CITY OF ALBUQUERQUE

April 28, 2015

**RE: Chaparral Elementary School Portable Relocation, 6325 Milne Rd. NW
Grading and Drainage Plan
Engineer's Stamp Date 4-20-2015 (File: F10-D005)**

RE: Chaparral Elementary School Portable Relocation
Grading and Drainage Plan
Engineer's Stamp Dated 4-14-15 (File: F10-D005)

SHEET TITLE
GRADING & DRAINAGE PLAN

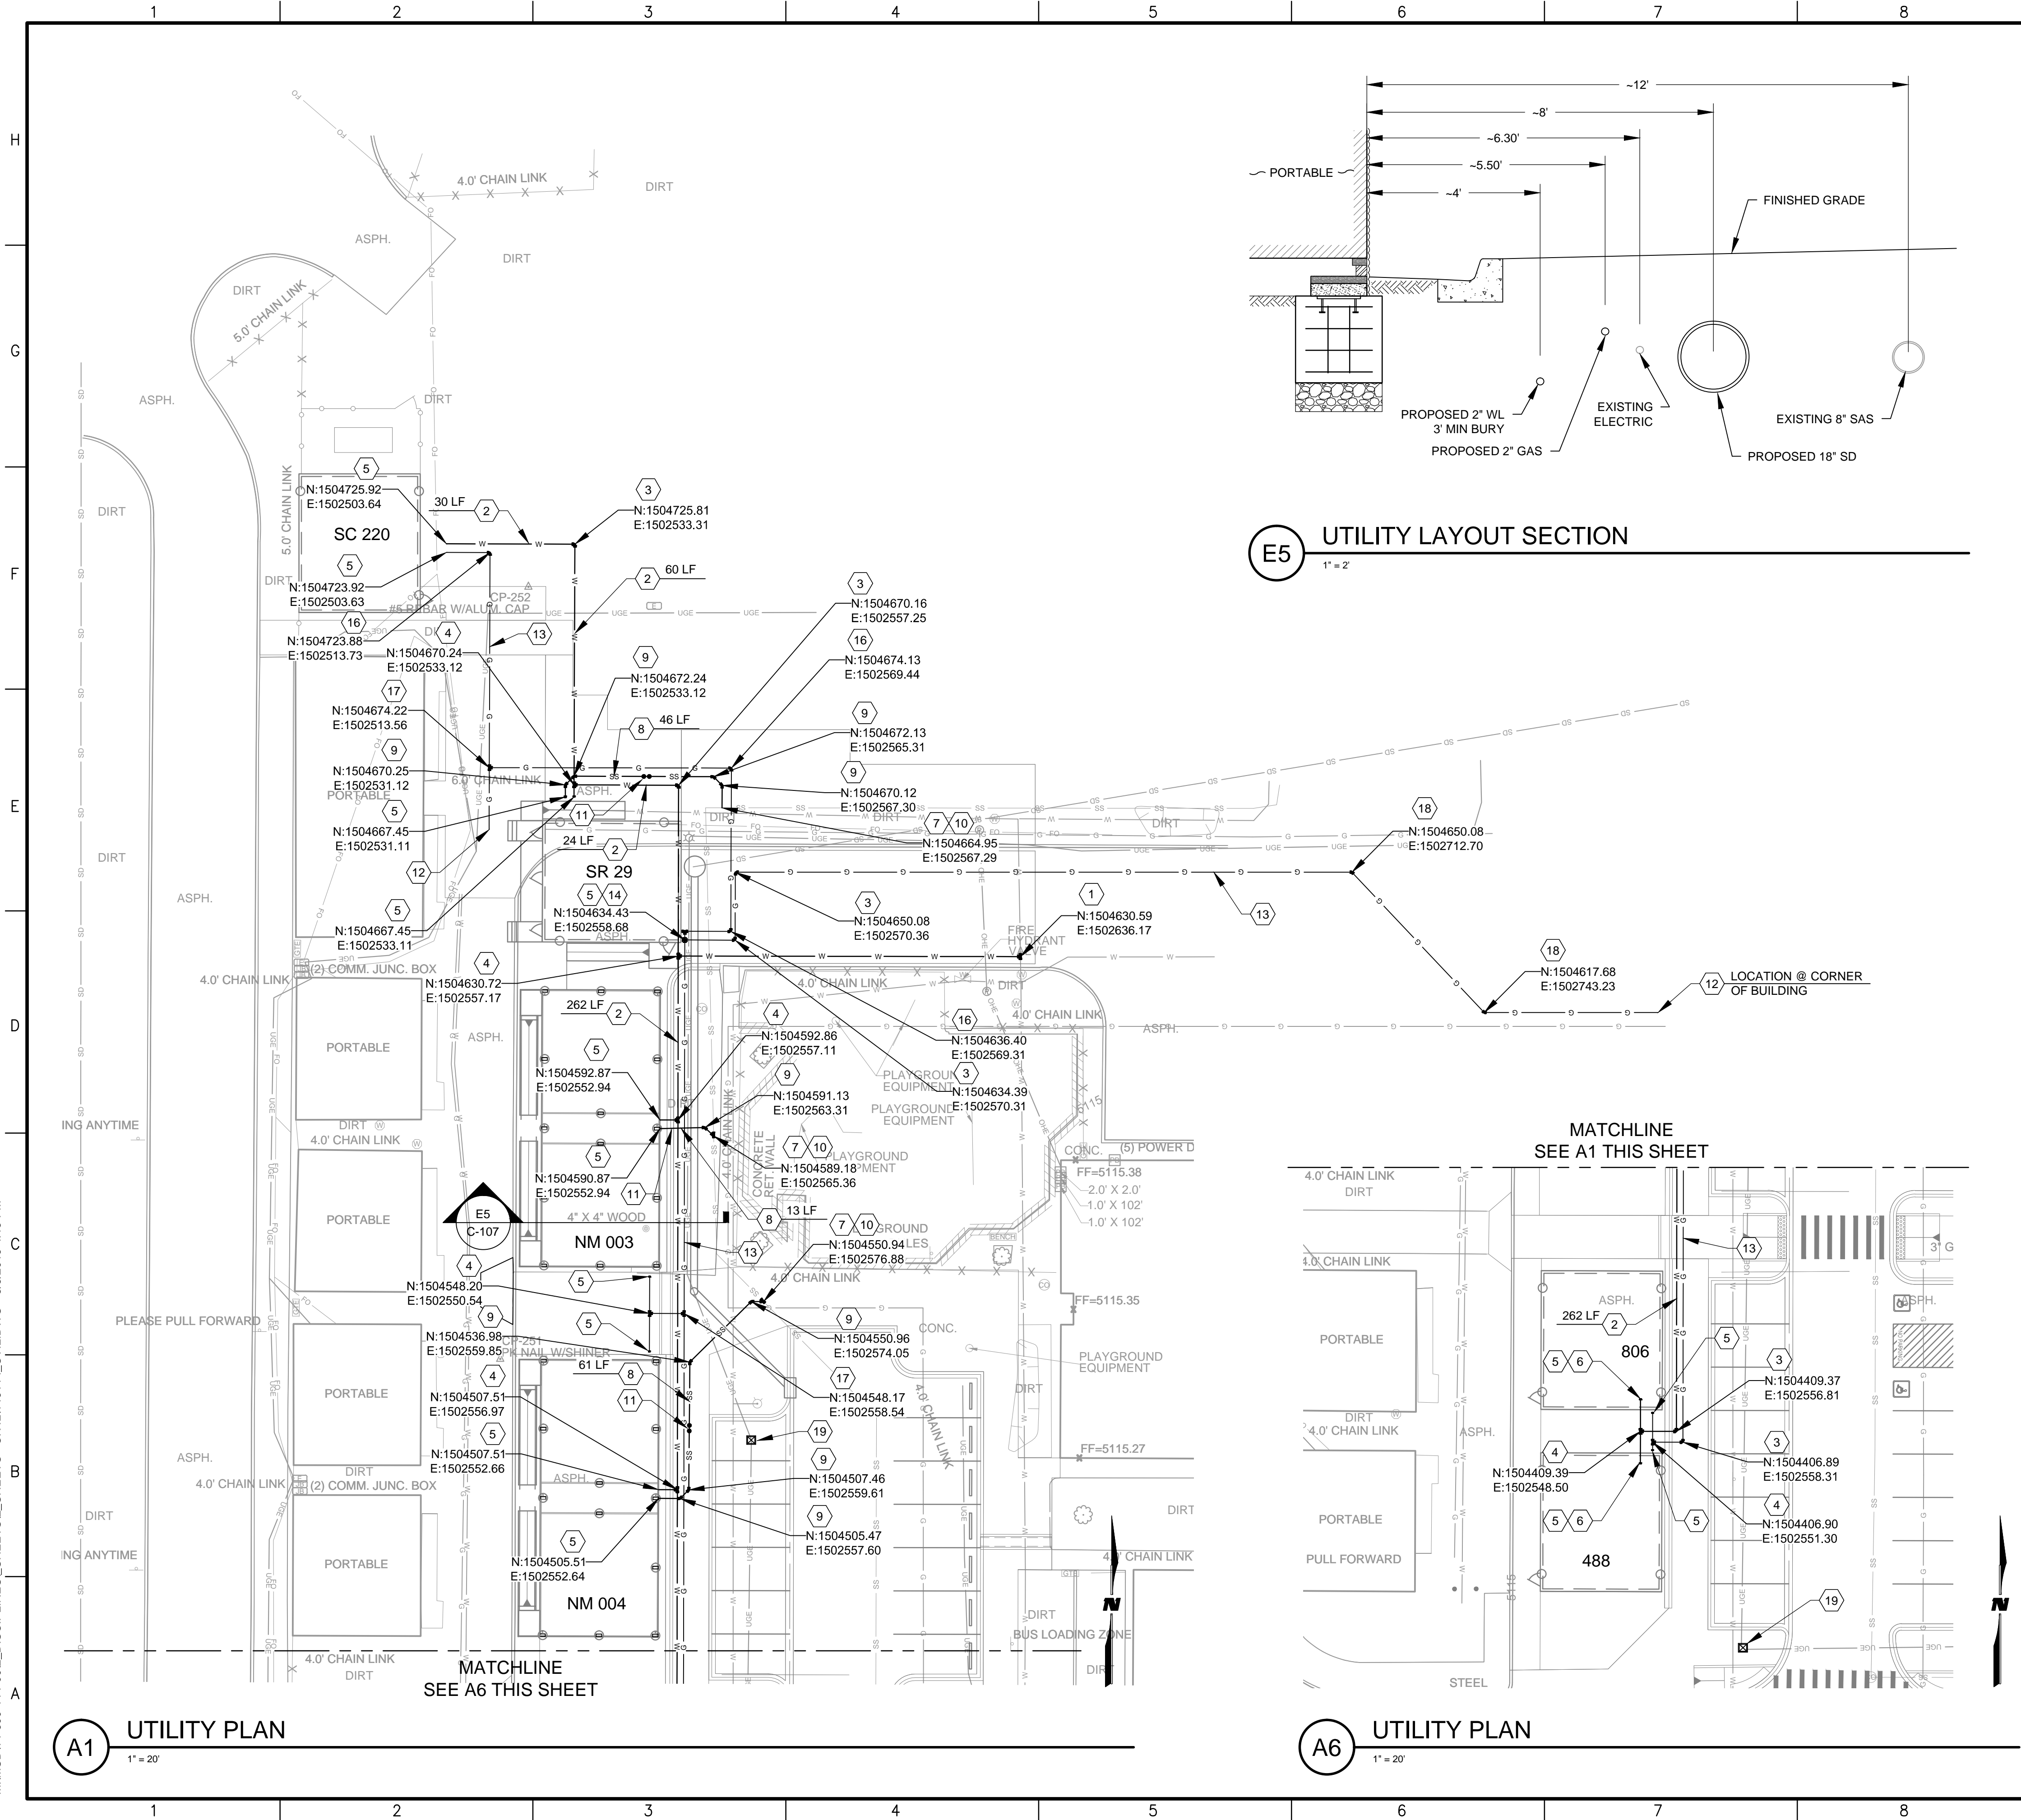
2. Analysis points have been included at pipe inlets and sidewalk culverts. Calculations were also included showing the capacity of the proposed structures.

3. The existing 18" storm drain pipe has been labeled and a proposed 100-year discharge of 11.94 cfs is also labeled.
4. Additional flow arrows showing the direction of runoff from the roofs of the portable buildings have been included. Any flow on the west side of the portable buildings will flow north passed the portable building than east toward the proposed curb & gutter. The direction of discharge in Basin 4A within this project continues to follow existing drainage patterns. The increase in impervious area is accounted for in the plans to develop Basin 4A which will proceed following the completion of the portable relocation project. Refer to Chaparral Elementary School Addition Plans for Proposed Developments layouts.

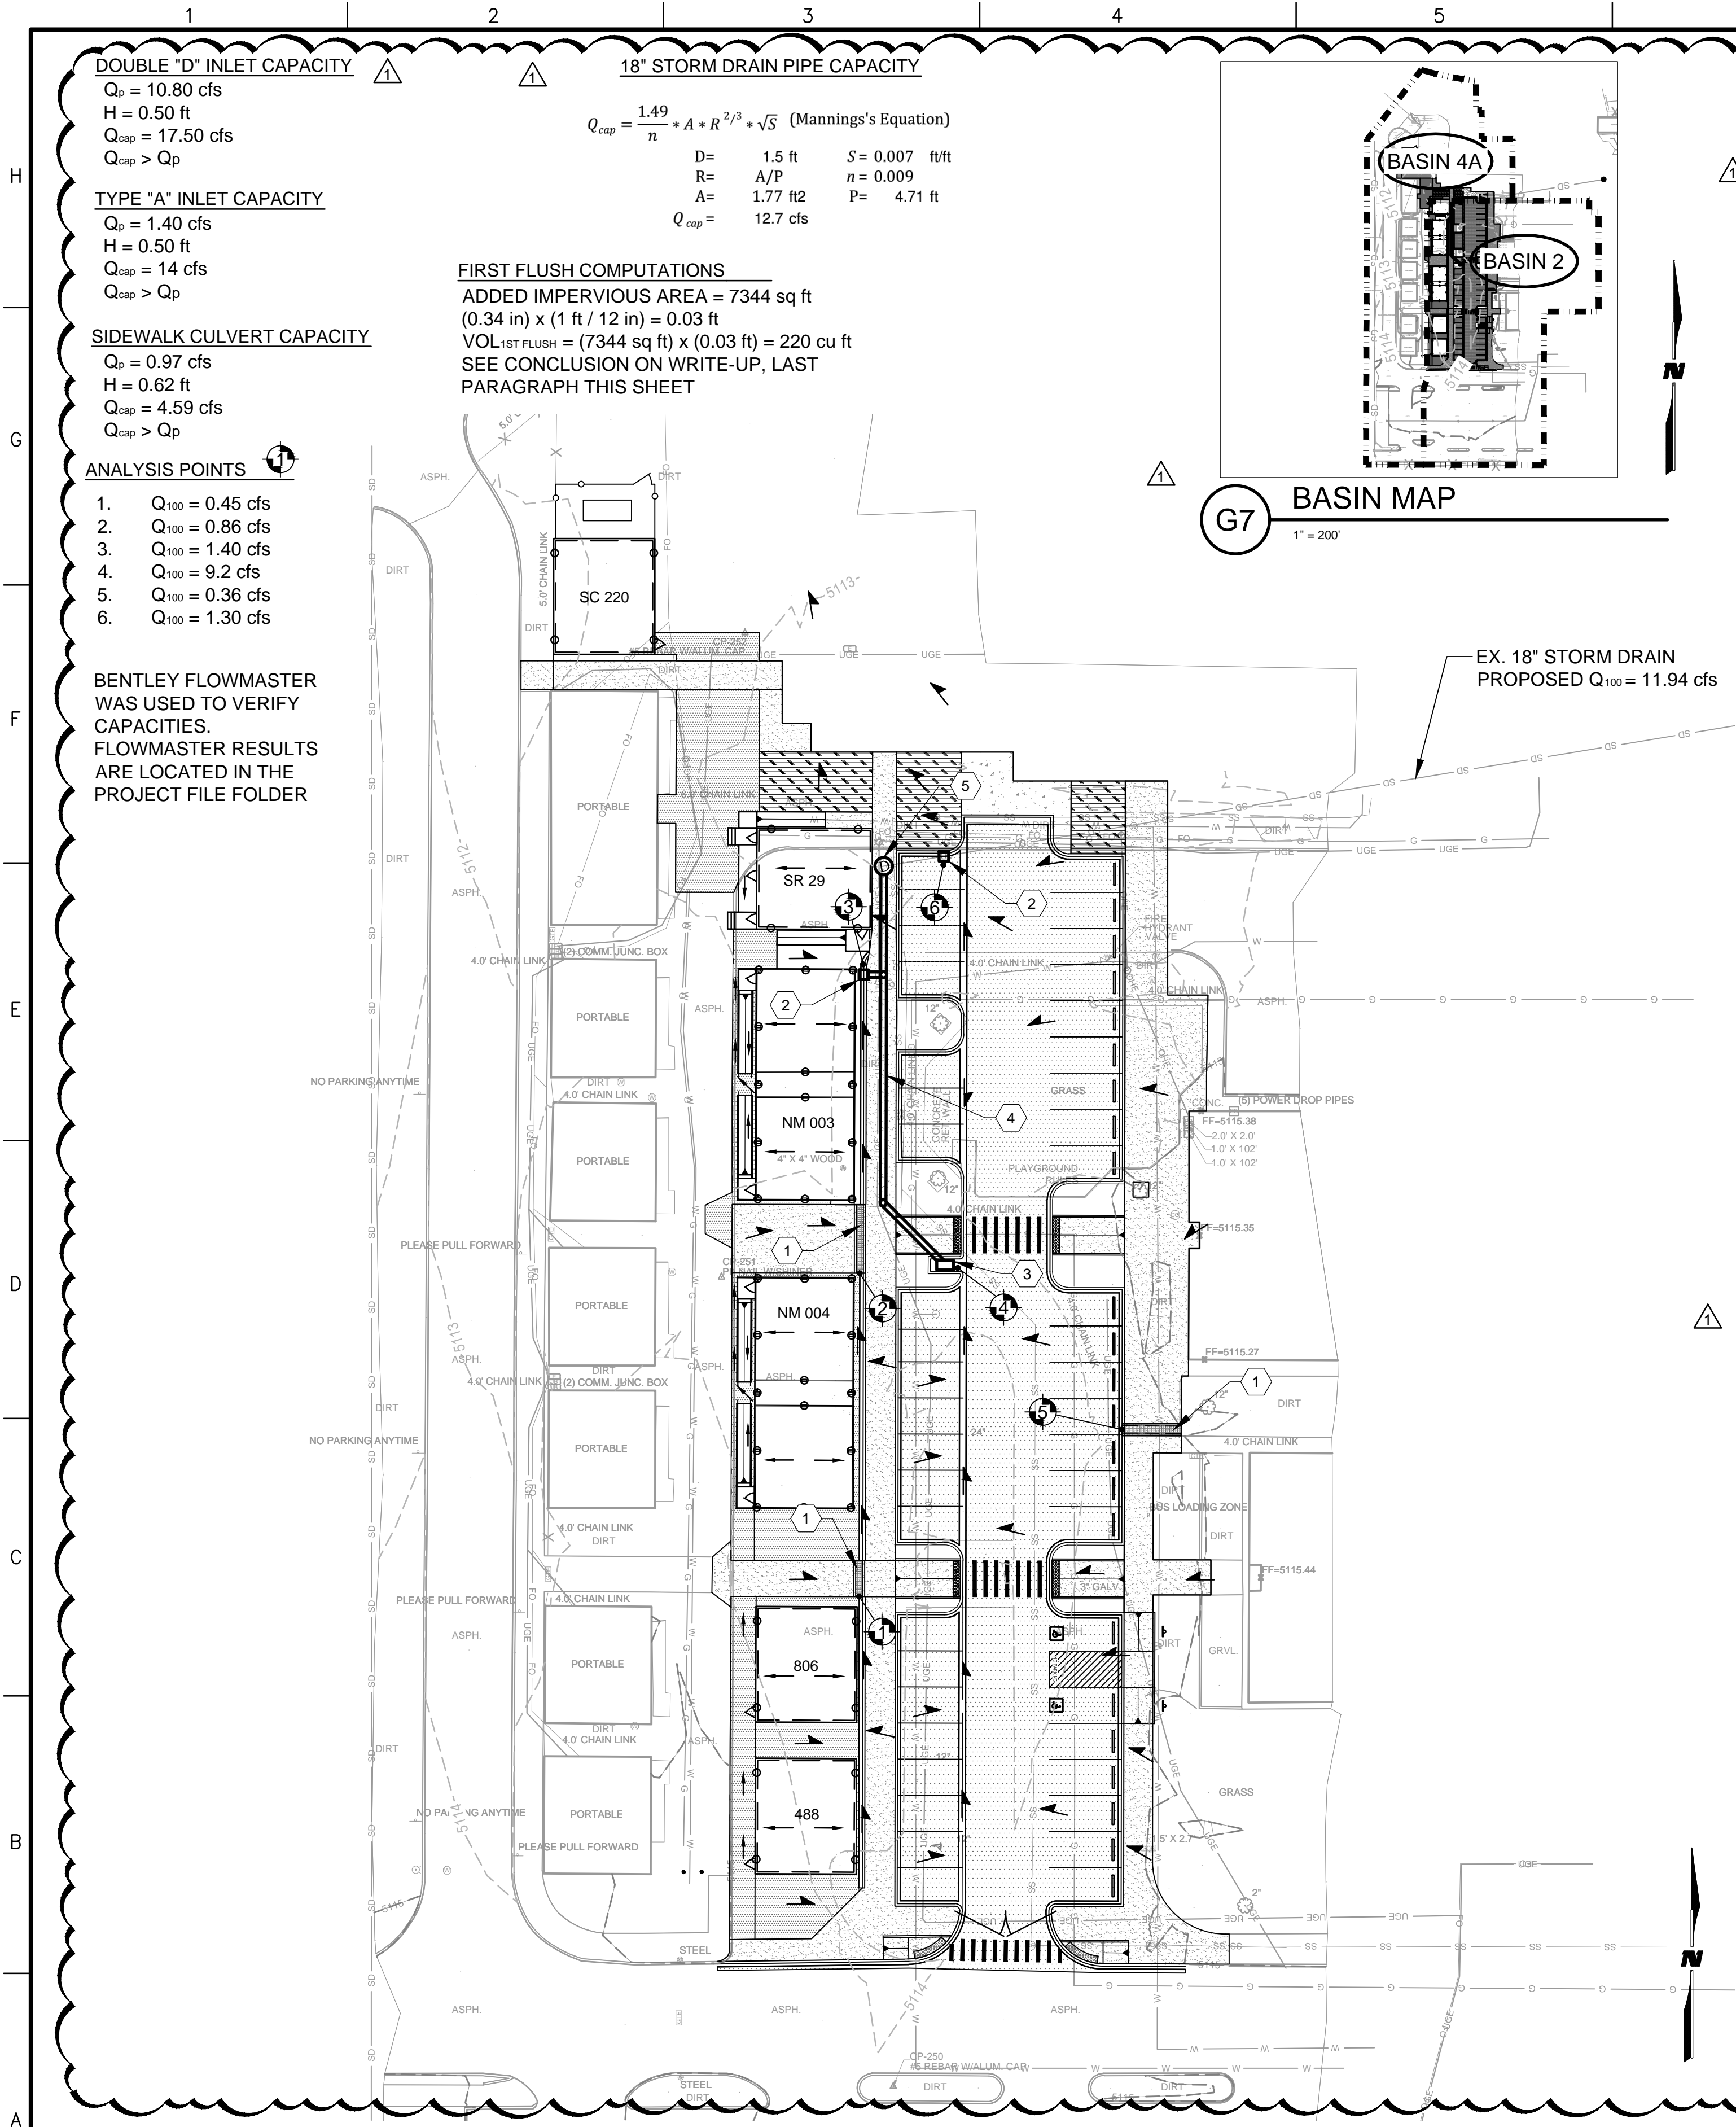
1. The first flush volume of 220 cubic feet will be conveyed to the Ladera Basin 16 sump which lies immediately east of the school site. The sump will allow any pollutants to settle out before entering the city storm drain system. The first flush computation have been included on the sheet.
